**KIRKLEES METROPOLITAN COUNCIL
INVESTMENT & REGENERATION SERVICE**

Reference No: 2019/62/94075/W

Site Address: 4, Olney Street, Slaithwaite, Huddersfield, HD7 5EG

Description: Erection of pair of semi-detached dwellings

Front elevation (1:100)

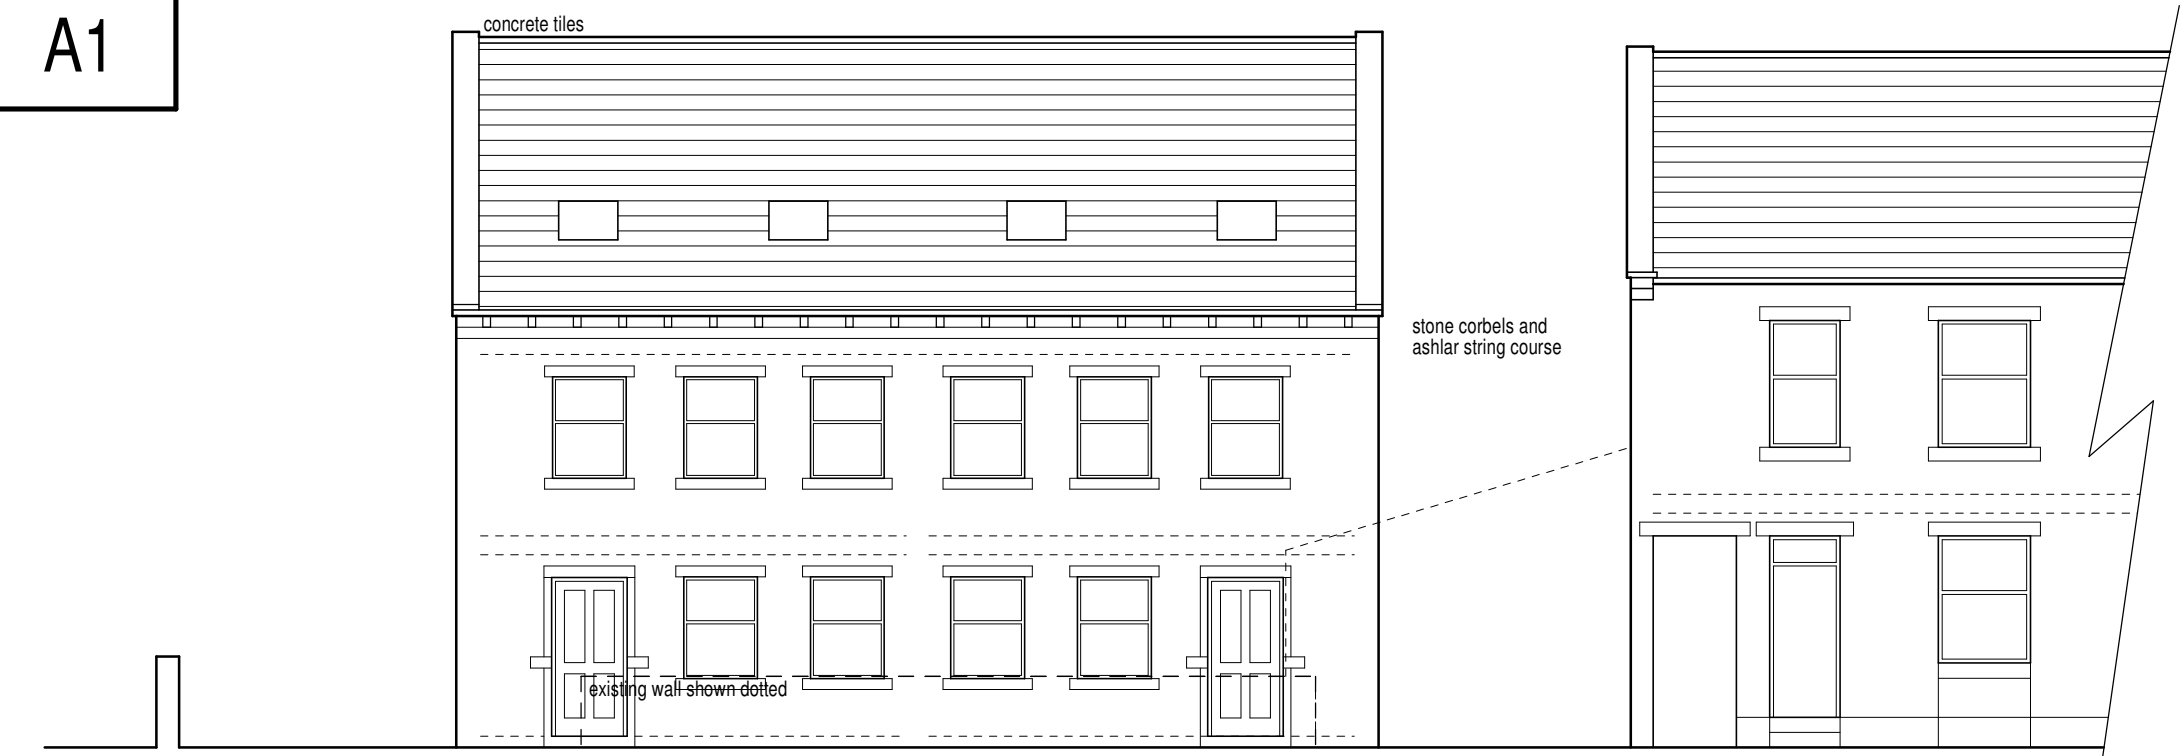
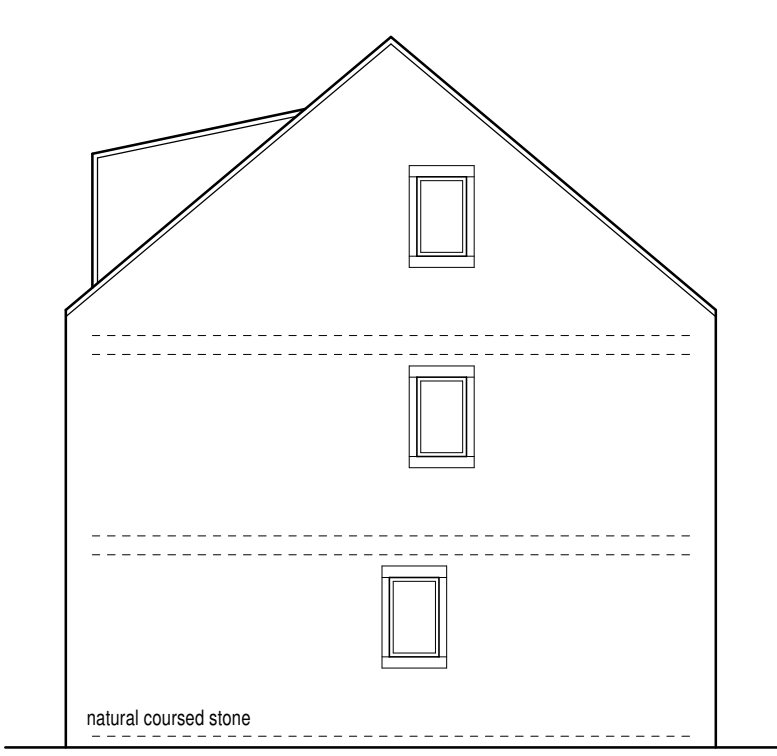
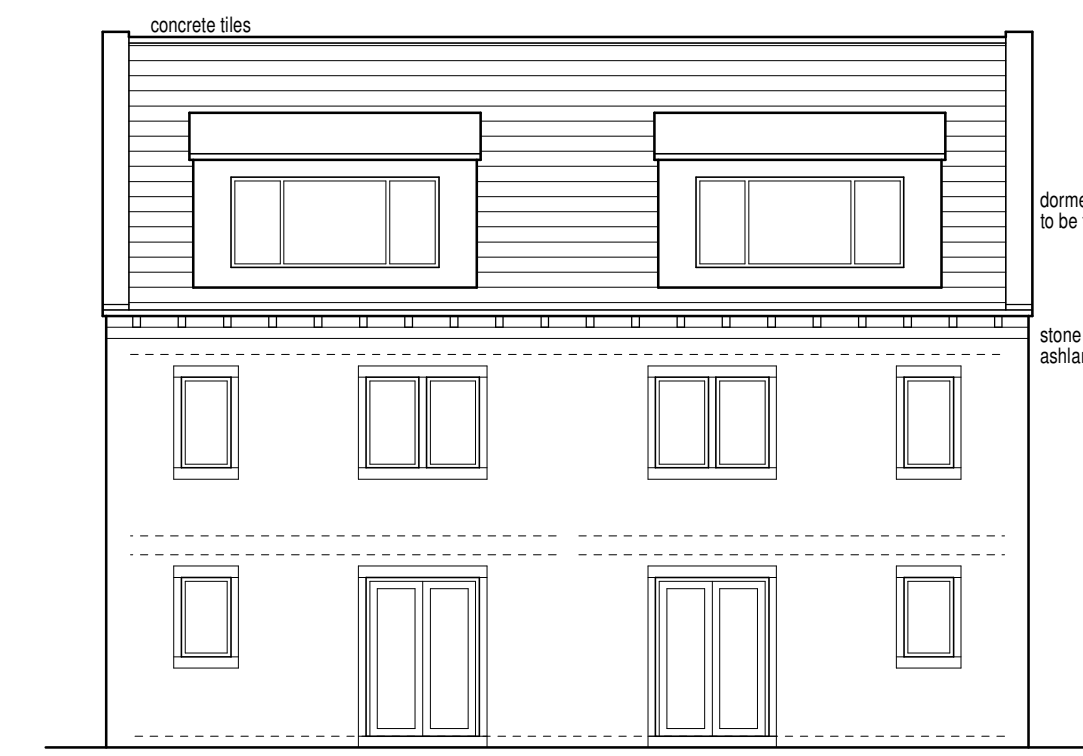
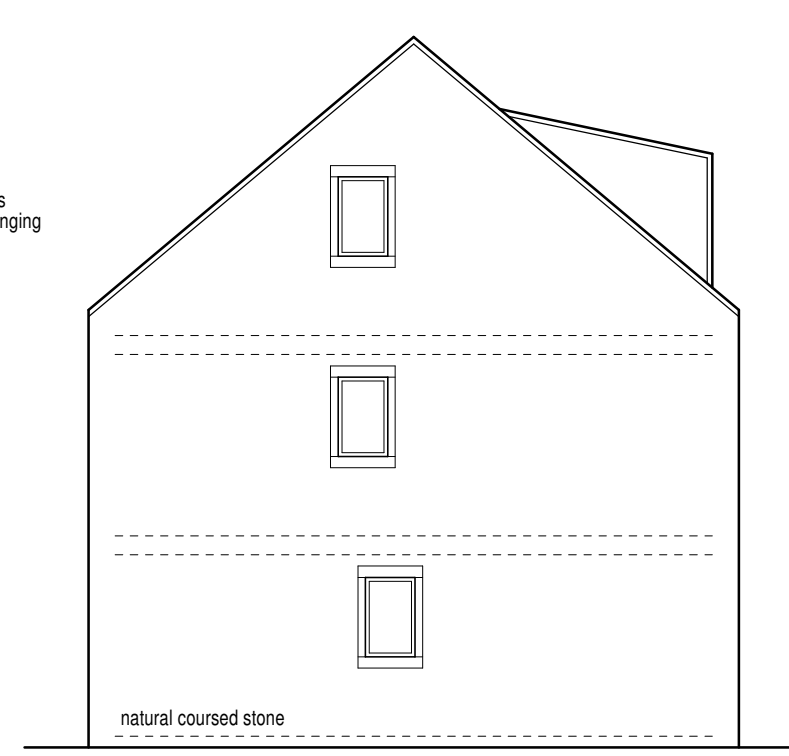
With regards to the design features, amendments have also been sought in order to incorporate a water tabling at either end of the building to reflect that on the adjacent property. Corbels and an ashlar string course is also included to reflect design details on the adjacent property.

Turning to the rear roof slopes, the submitted plans show one modest sized dormer to be inserted on the rear elevation of each dwelling. These would be constructed from hanging tiles to match the host property. In regards to the size and scale of the dormers, it has been considered that they would be set down from the ridge roof line and up from the eaves. The flat roof design, also helps to reduce some of the bulk and massing within the roof space. More importantly, the change in land levels within the vicinity further alleviates some of the impact and therefore it has been considered that the benefit of providing a third bedroom at second floor would outweigh any visual concern. The dwellings, are also carefully contained between two residential properties and therefore the proposed dormers would not appear overly prominent within the street scene.

Proposed site plan 1:200.

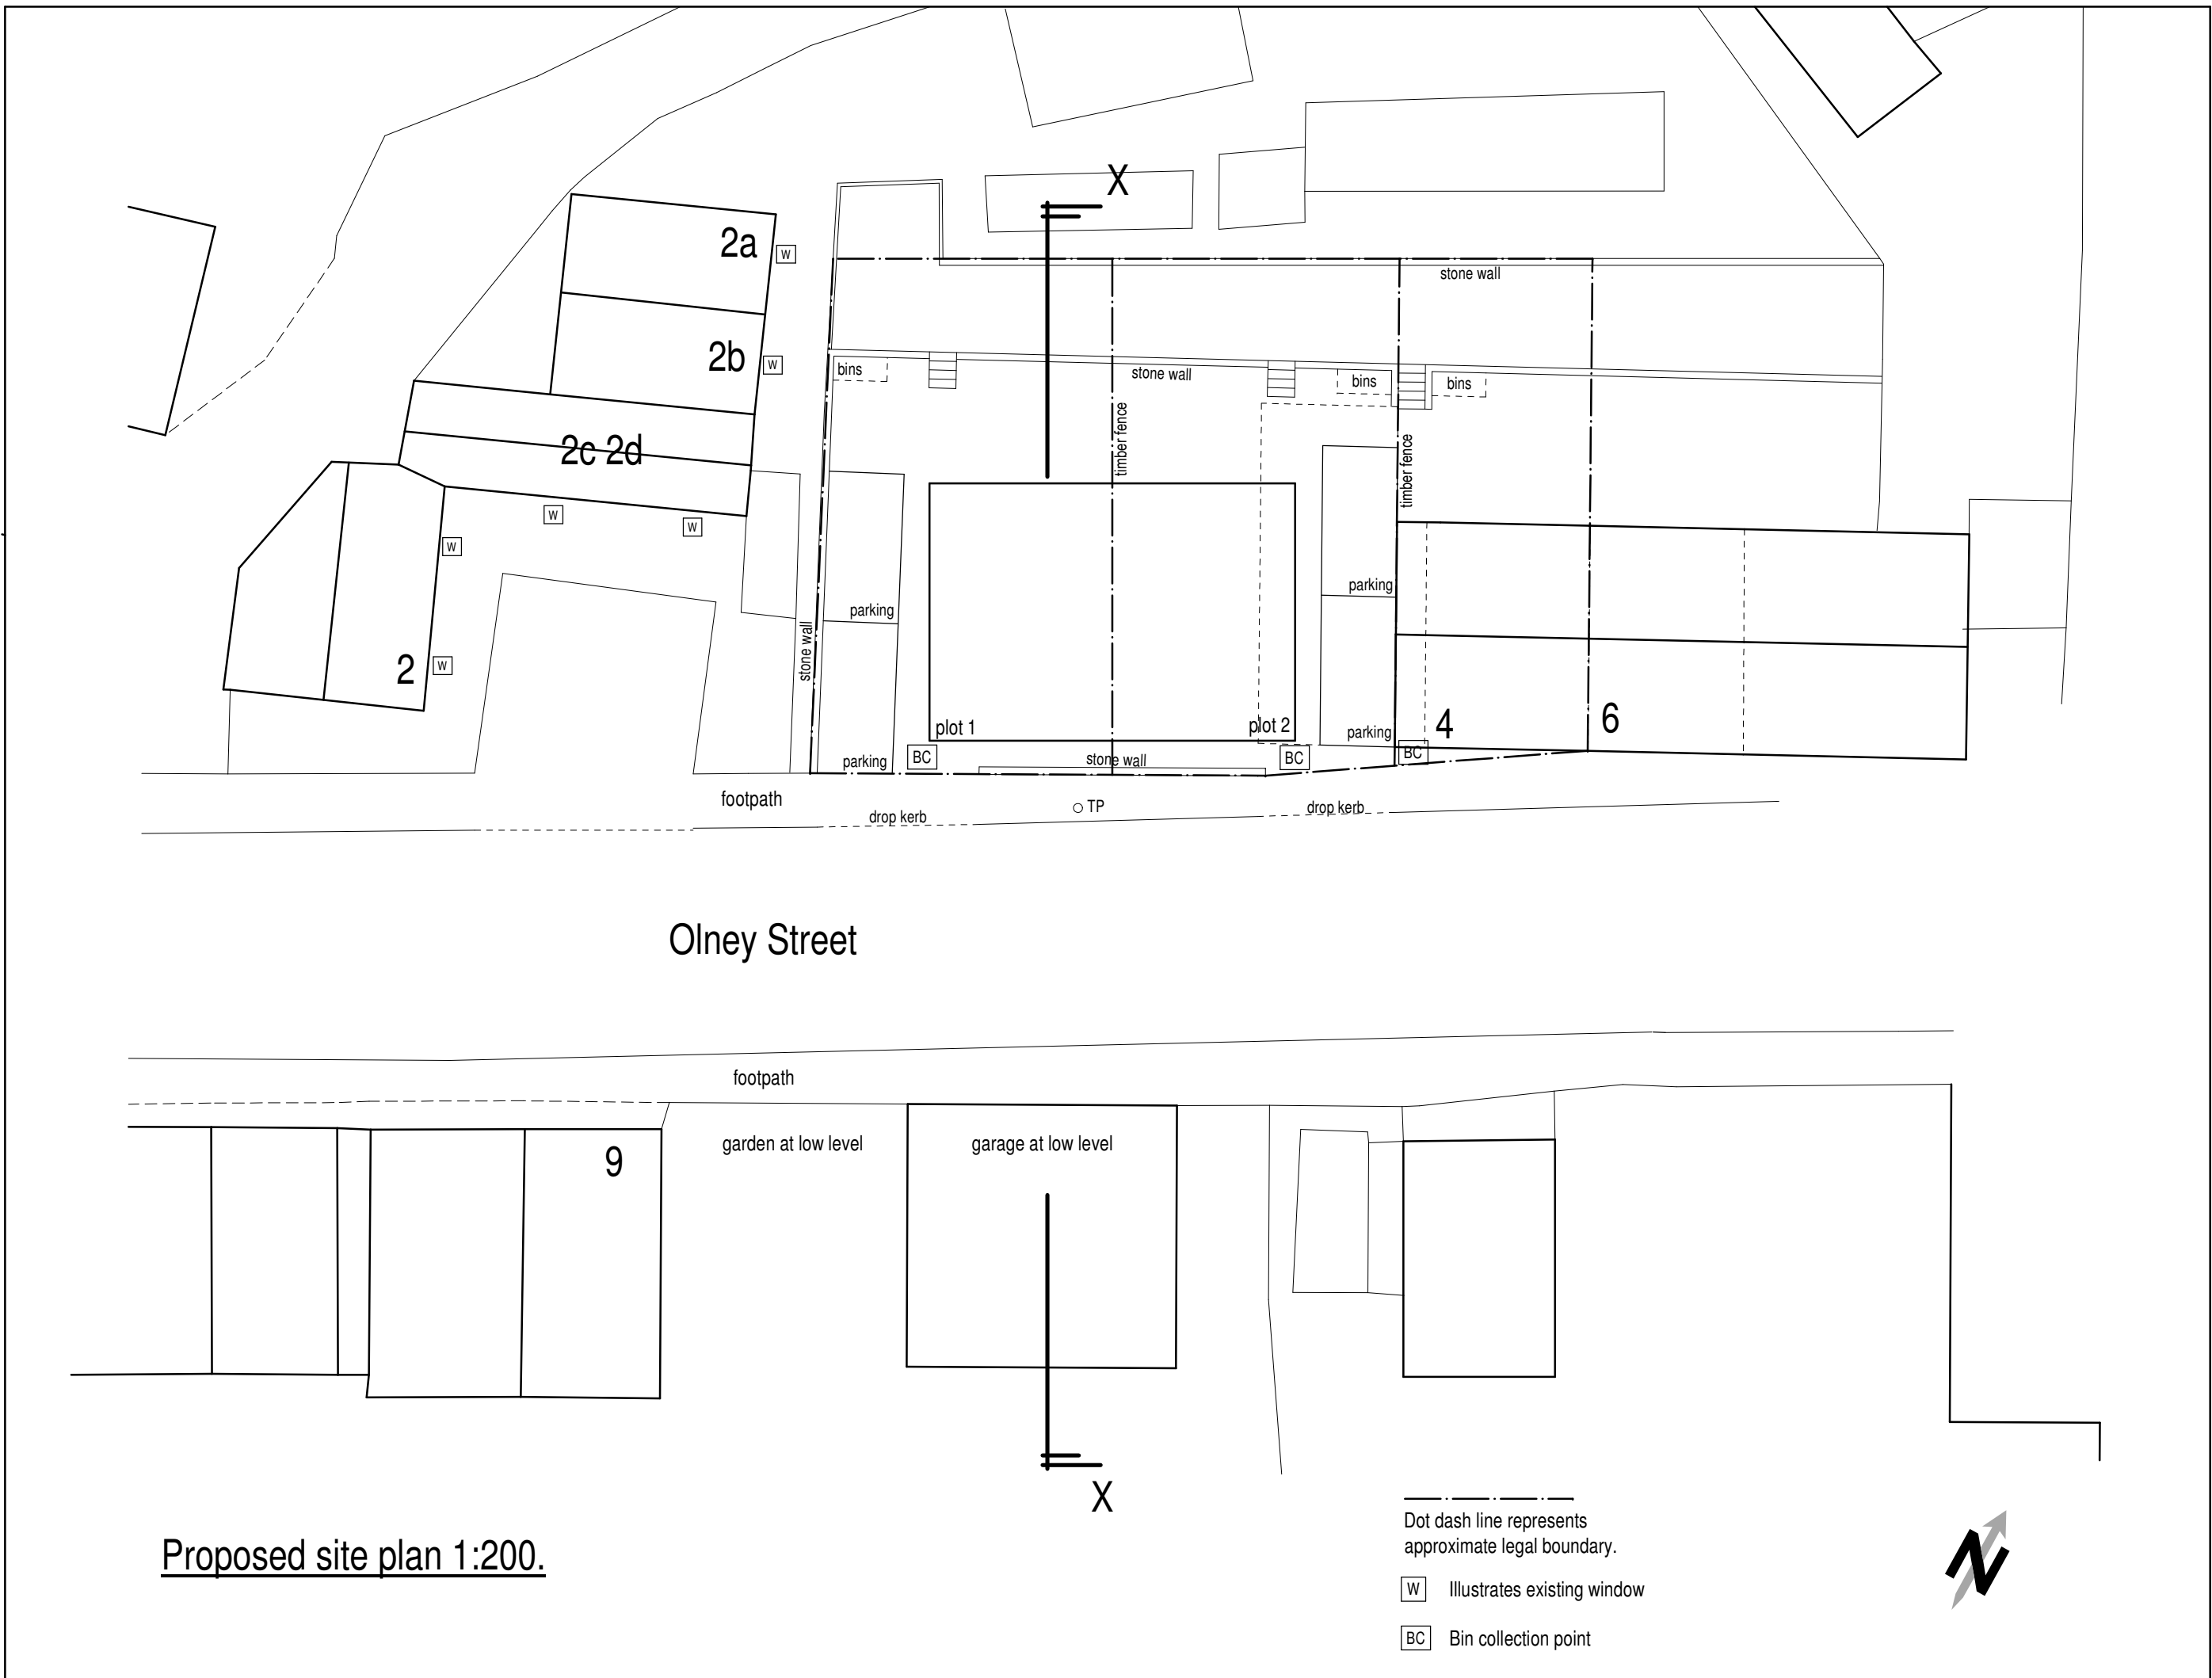
The existing double garage at no.4 Olney Street will be demolished as part of this proposal. Bin storage for the existing and new dwellings have been demonstrated on the site plan OS P 01 Rev B.

The officer entered into discussions with the agent regarding the proposed roofing materials and the design features shown on the submitted plans. Concerns were also raised following the consultation response from KC Highway DM with regards to the proposed bin storage and collection point. As such, an amended plan was received on the 11th February to overcome some of these concerns.

With regards to bin storage, initial concern was raised by KC Highways DM as the bin location would be to the rear of the properties behind the parking areas. As such, an amended plan has been submitted to the council, to show the new bin location to be at the front of the dwelling, which have been considered acceptable from a highways perspective.

Proposed section X - X 1:200 @ A1.

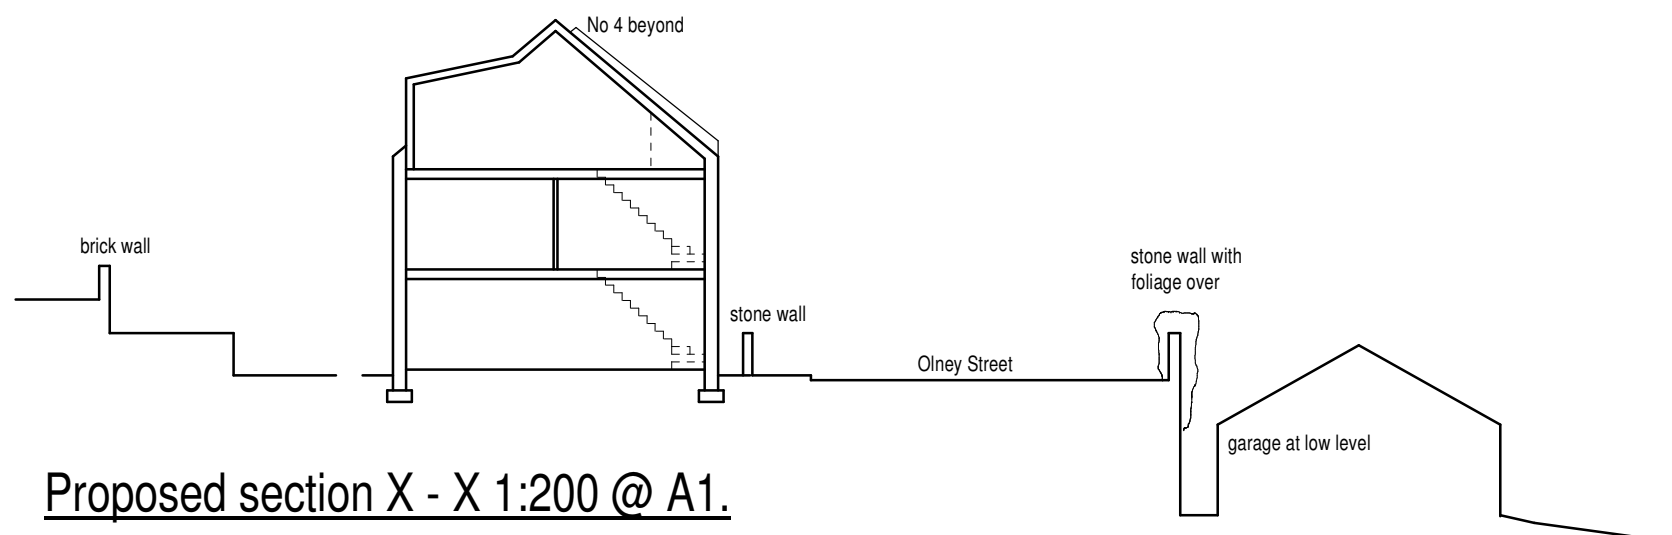
Given the above it has been considered that the overall size and scale of the residential properties would appear sensitive to the character and context of the area and would therefore sit comfortably within the street scene. This is demonstrated within the section plan, which shows the proposed dual pitch roofs to sit at a similar height as the row of terrace properties to the east. As such, officers are satisfied that the dwellings will not have an oppressive nor overbearing impact when viewed within the street scene and will harmonise with the general character of the surrounding properties in accordance with Policy LP24 of the Kirklees Local Plan.
